## Appeal Decision

**Appeal ref: APP/T2350/D/22/3313818**

**1 Park Road, Gisburn, Lancashire BB7 4HT**

- The appeal is made under section 78 of the Town and Country Planning Act 1990 against a refusal to grant planning permission under section 73A of the Town and Country Planning Act 1990 for development carried out without planning permission.
- The appeal is made by Mr Paul Hargreaves/Green Planet Energy against the decision of Ribble Valley Borough Council.
- The application, ref. 3/2022/0440 dated 3 May 2022, was refused by a notice dated 4 October 2022.
- The development proposed is the retention of garden room/home office and garden shed.

PLAN & ELEVATIONS OF GARDEN ROOM/OFFICE & STORE FOR
MR & MRS P HARGREAVES 1 PARK RD GIBURN

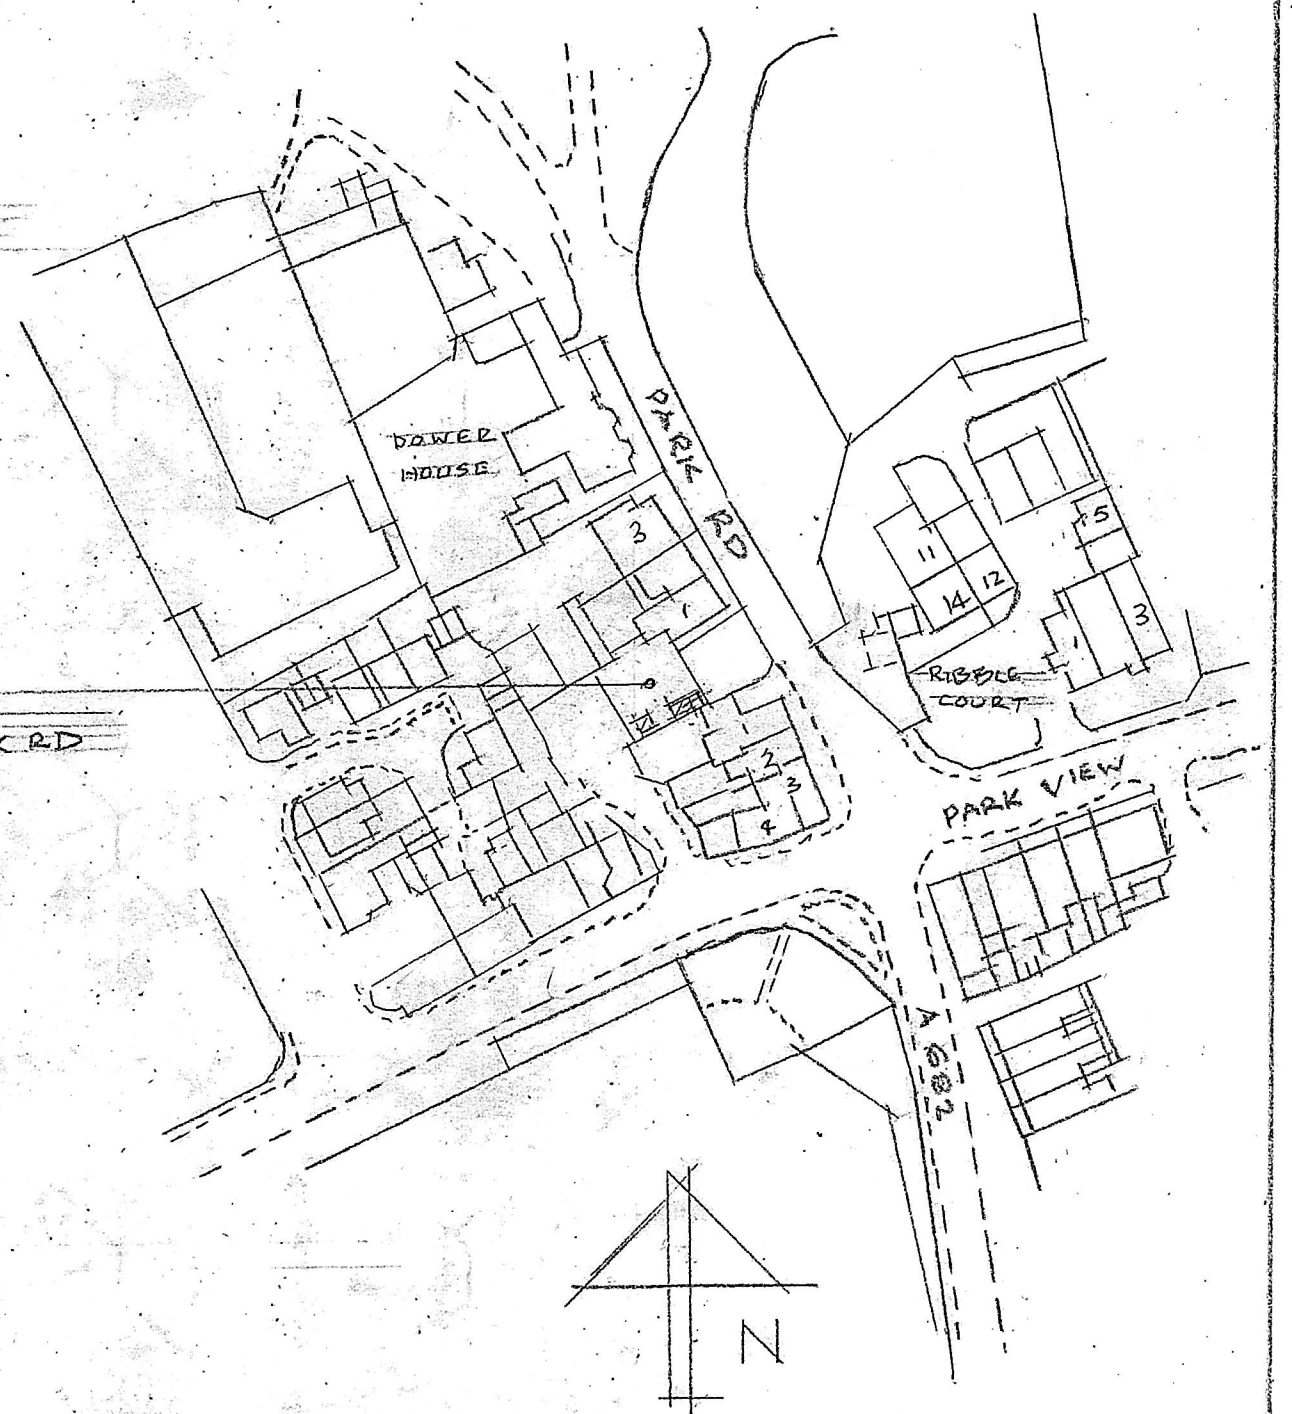
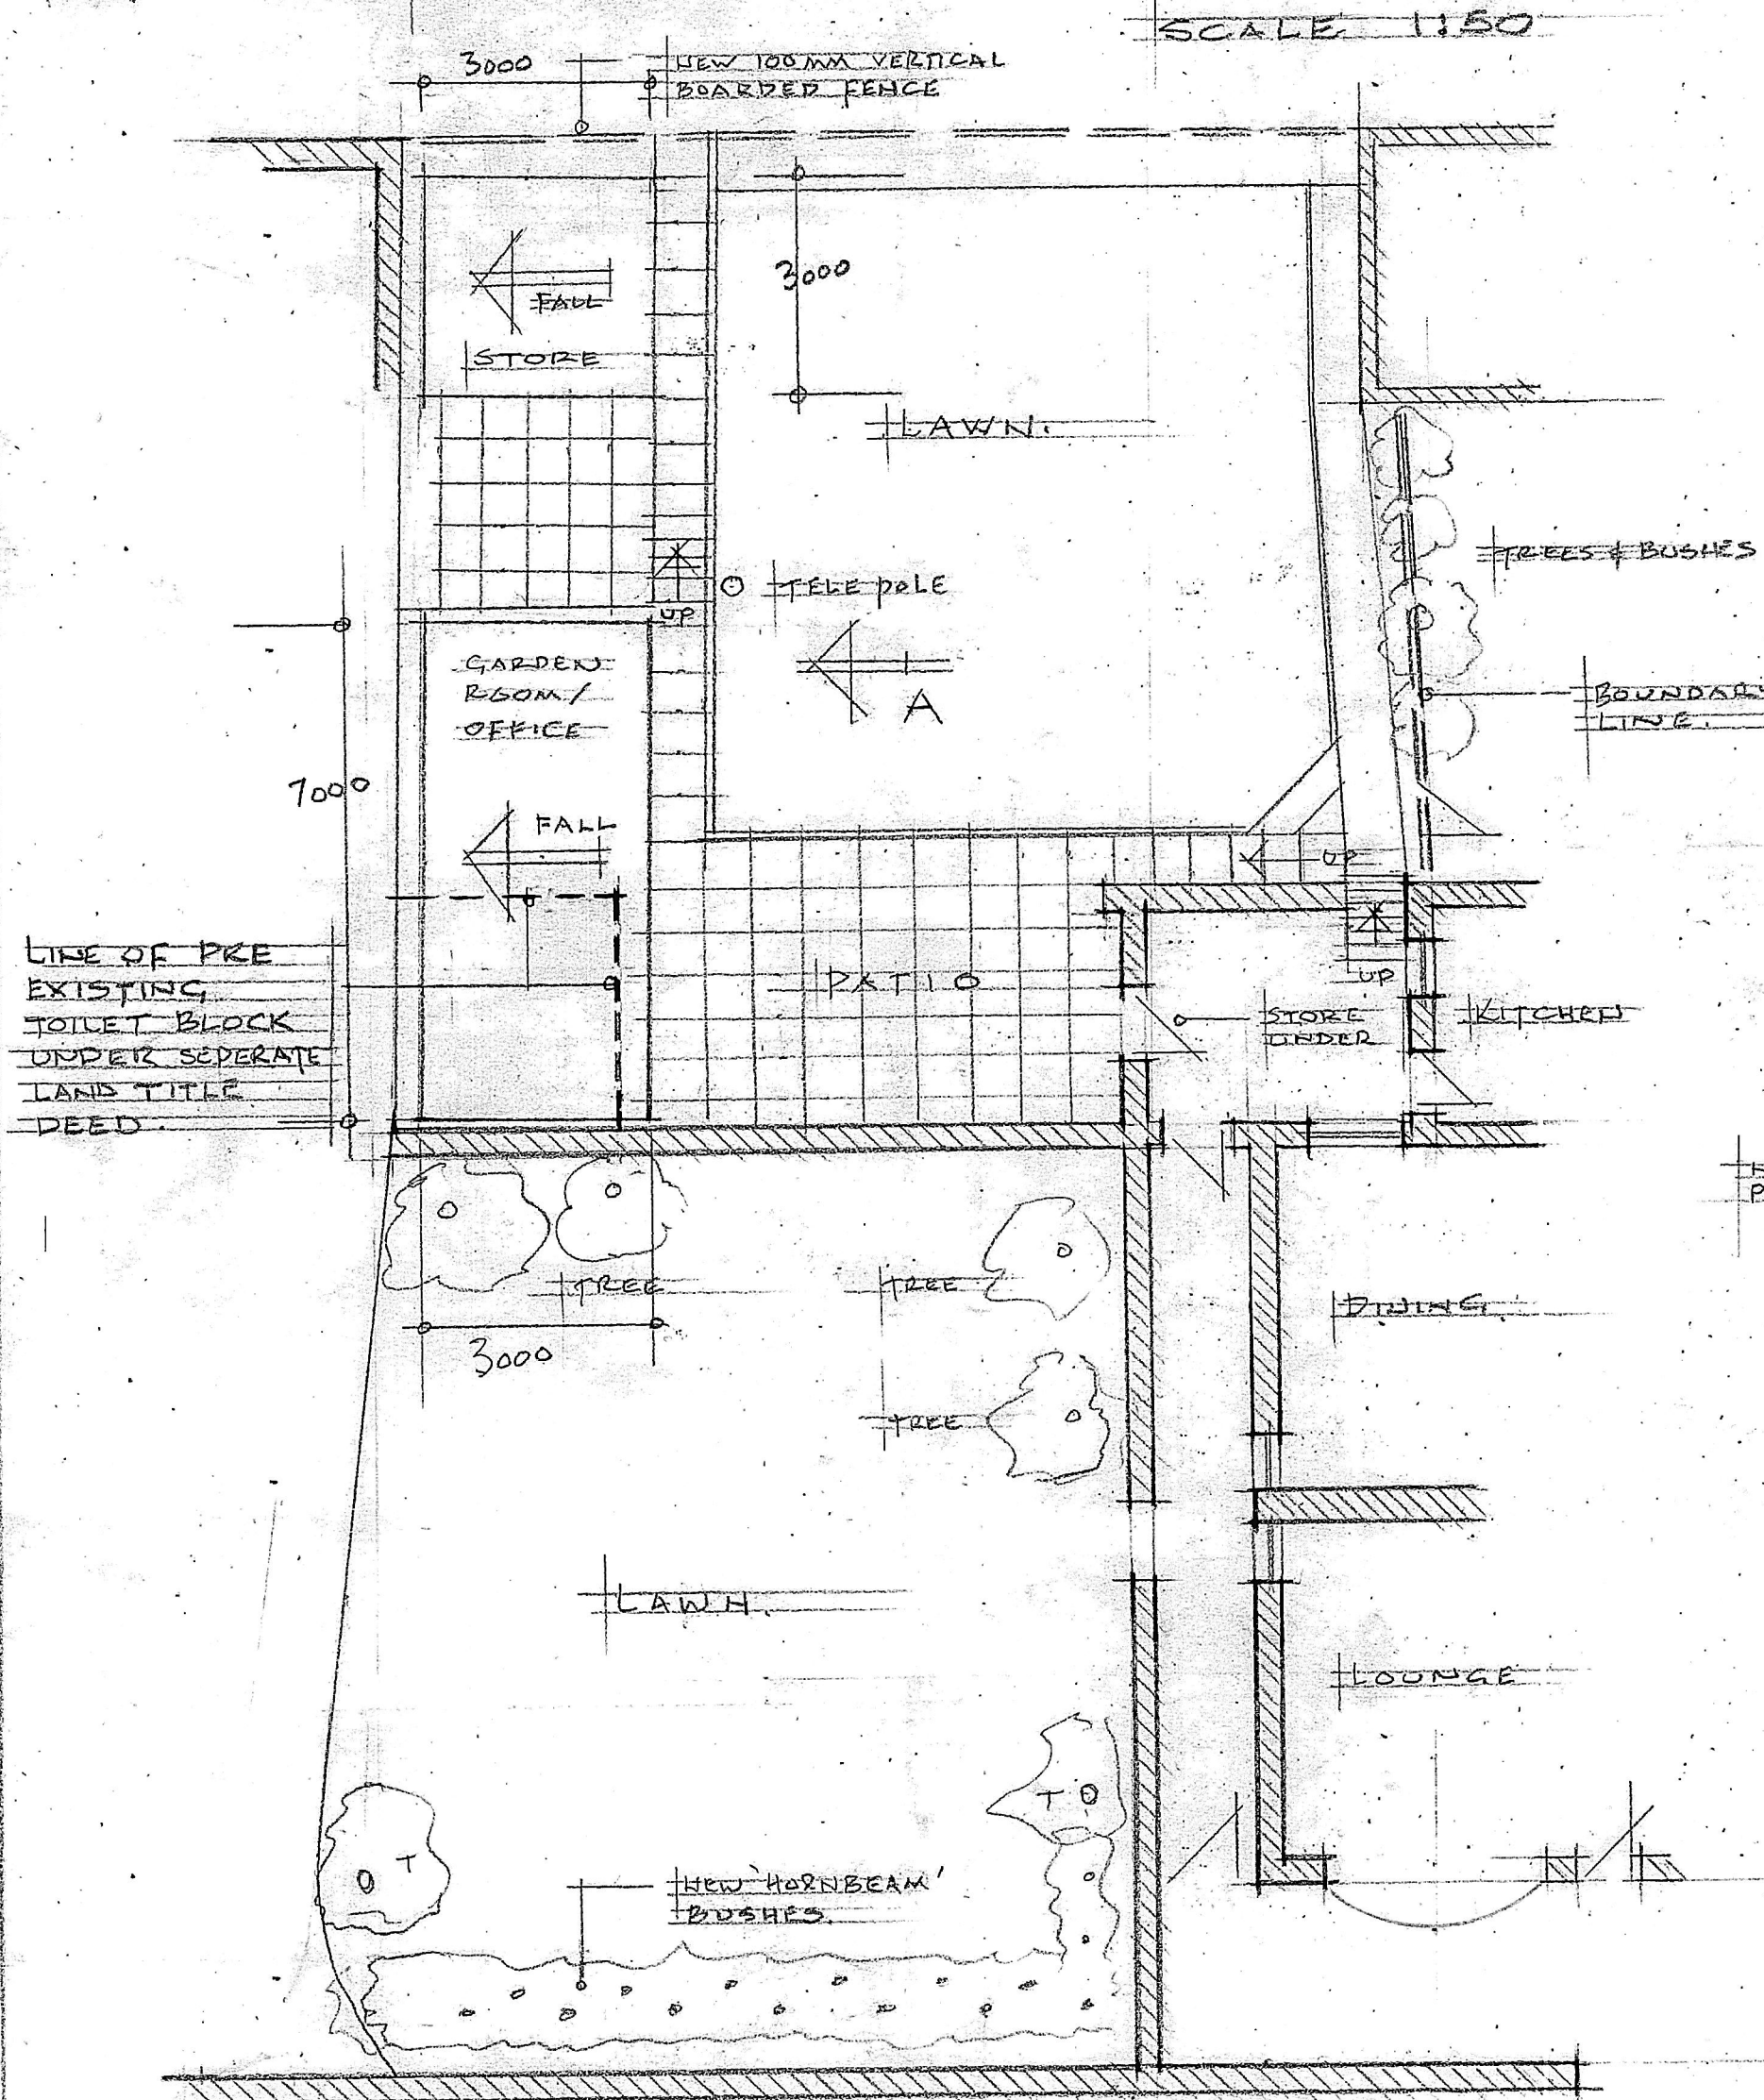
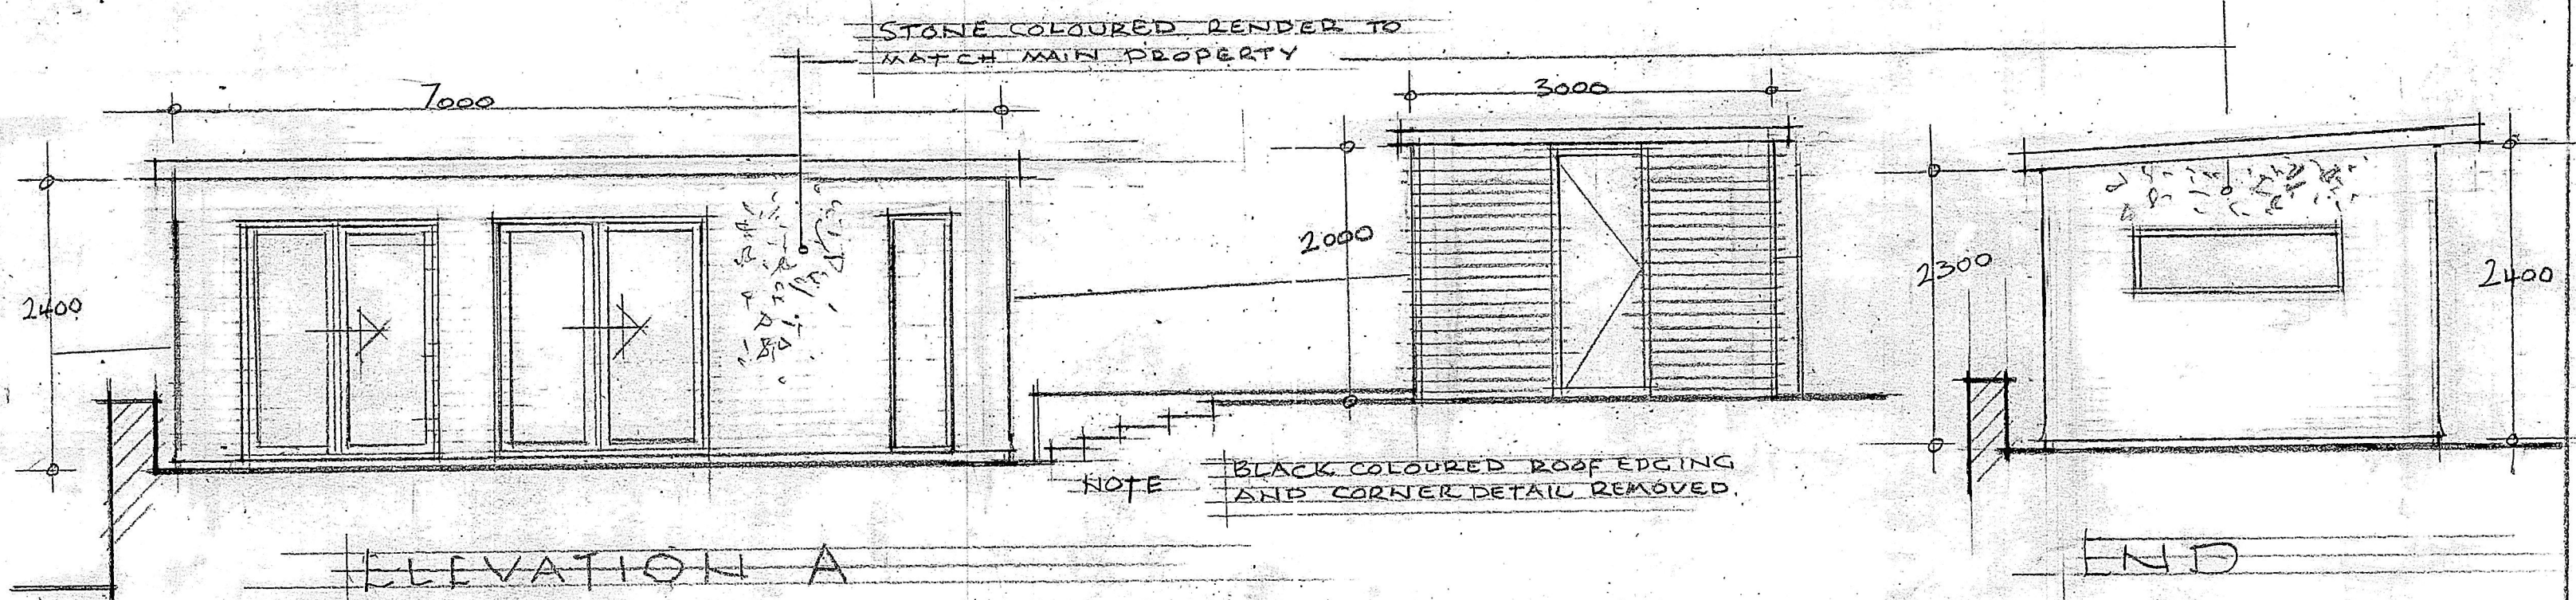
3. The appeal application seeks planning permission for the retention of 2 flat roofed outbuildings in and near the end of the side garden of 1 Park Road. The garden room/office building is 7m long, 3m wide. The smaller store appeal building covers 3m x 3m. Each building is 2.4m high clad with horizontal timber boards. Both have deep black plastic facias and vertical corner edging.

5. The Appellant, Mr Hargreaves, sought to address those concerns by suggesting the removal of the black edging to the roof eaves and corners and applying stone coloured rendering to the north and east elevations of the 2 outbuildings. He said that would simplify the design and reduce their visual impact. The works would minimise any visual harm to the setting of the adjacent Grade II

6. Whilst having regard to the views of the Inspector dealing with the previous appeal decision of November 2021, I am not bound by his conclusions. I do agree, however, with his opinion that the black roof and corner edging to the appeal outbuildings is particularly unsightly. If his decision could be taken to imply that removal of the edging might also remove any residual objections to the retention of the buildings, that is not a view I share.

8. The larger appeal outbuilding stands prominently above Park Road, somewhat emphasising its incongruity within the garden of the house at No. 1. When seen from Park Road and down Park Mews from the A59 trunk road, the 2 flat roofed timber clad appeal outbuildings appear unhappily obtrusive and ill-fitting. That is especially so when contrasted with the pitched stone and slate roofs of nearby long-established buildings.

9. I conclude that the 2 appeal outbuildings fail the test of meeting the duty under s.72 of the Planning (Listed Buildings and Conservation Areas) Act 1990, as amended, that .... with respect to any buildings or other land in a conservation area, ..... special attention shall be paid to the desirability of preserving or enhancing the character or appearance of that area, (s.71A of the Act) and that planning permission for their retention should be withheld. No planning conditions could be applied such as to override that decision.
